Re: SSD- 81890707 10,14 &14a Stanhope Road Killara – amended application

Friends of Ku-ring-gai Environment Inc (FOKE) are submitting a formal **objection** to the amended SSD. The SSD will result in significant adverse impacts to environmental, cultural, social and economic values of the area.

Figure 12: Shadow diagrams of the proposed development (Source: PBD Architects)

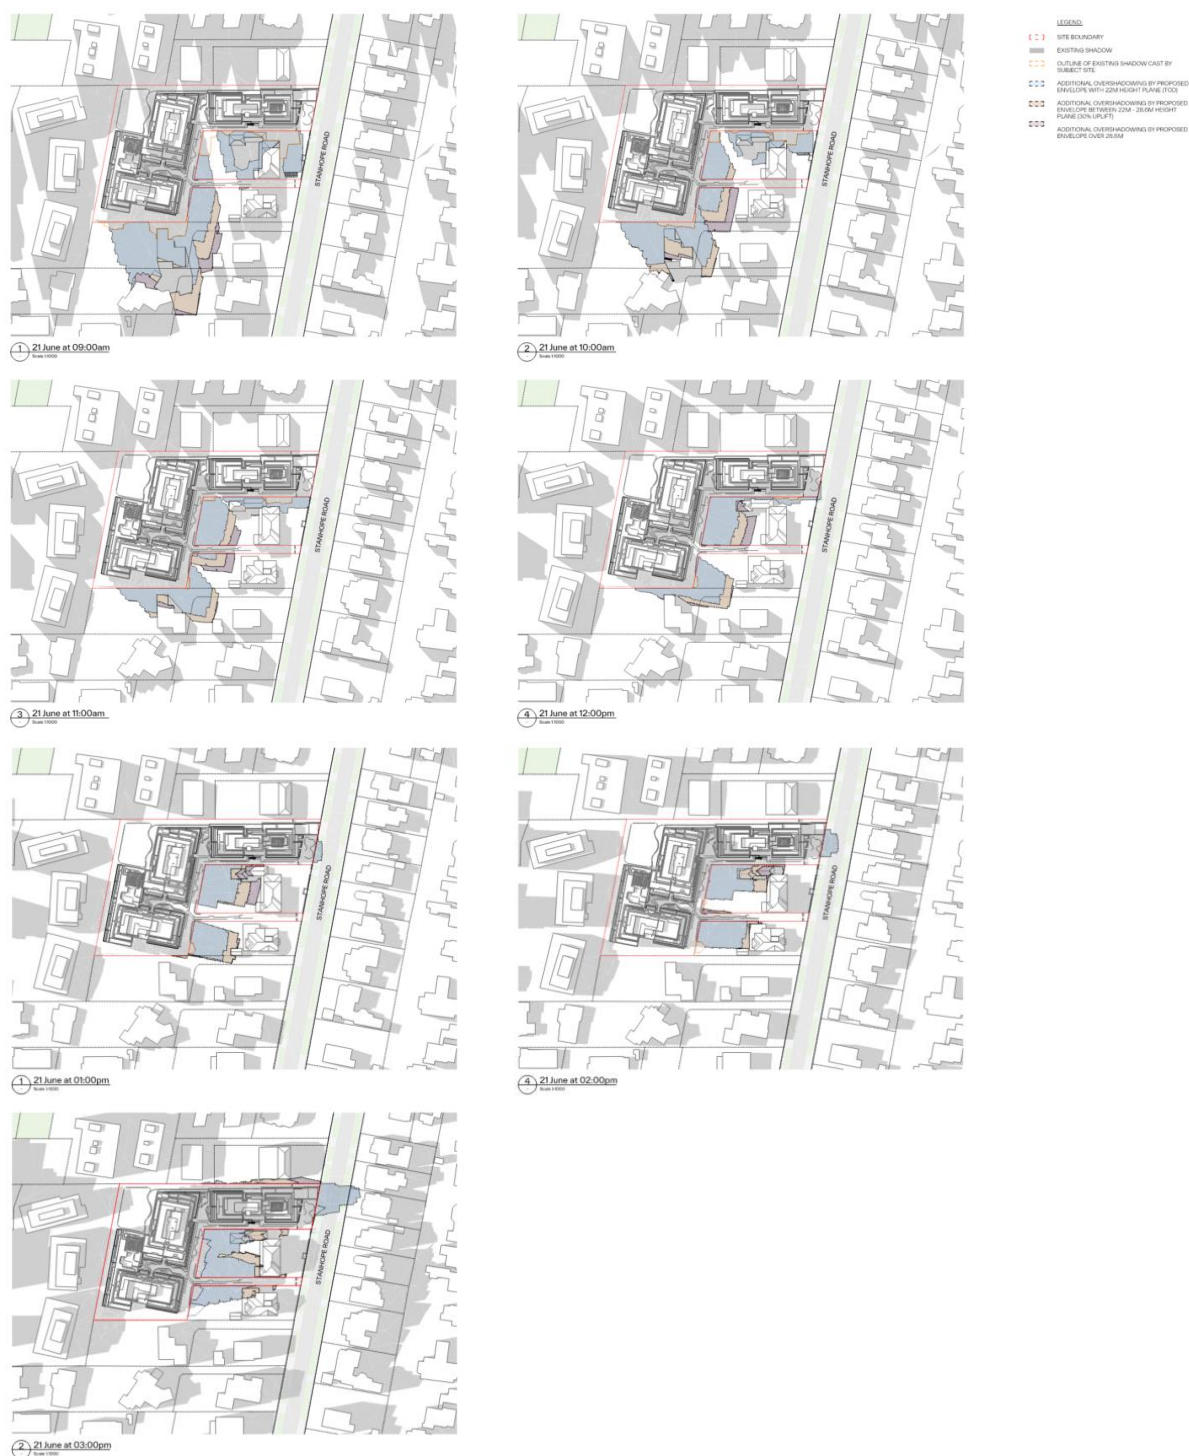
- The shadow diagrams highlight the massive overshadowing that will occur to the adjoining properties in Stanhope Road.
- Shadowing diagrams show that neighbouring properties in Stanhope Road are in shadow the majority of the morning in winter.

- Solar Access requirements in the KDCP are NOT MET. It is a requirement that
 - Three hours of direct sunlight between 9am and 3pm on 21st June is to be maintained to the living rooms, primary private open spaces and any communal open spaces within residential development in adjoining lower density zones.
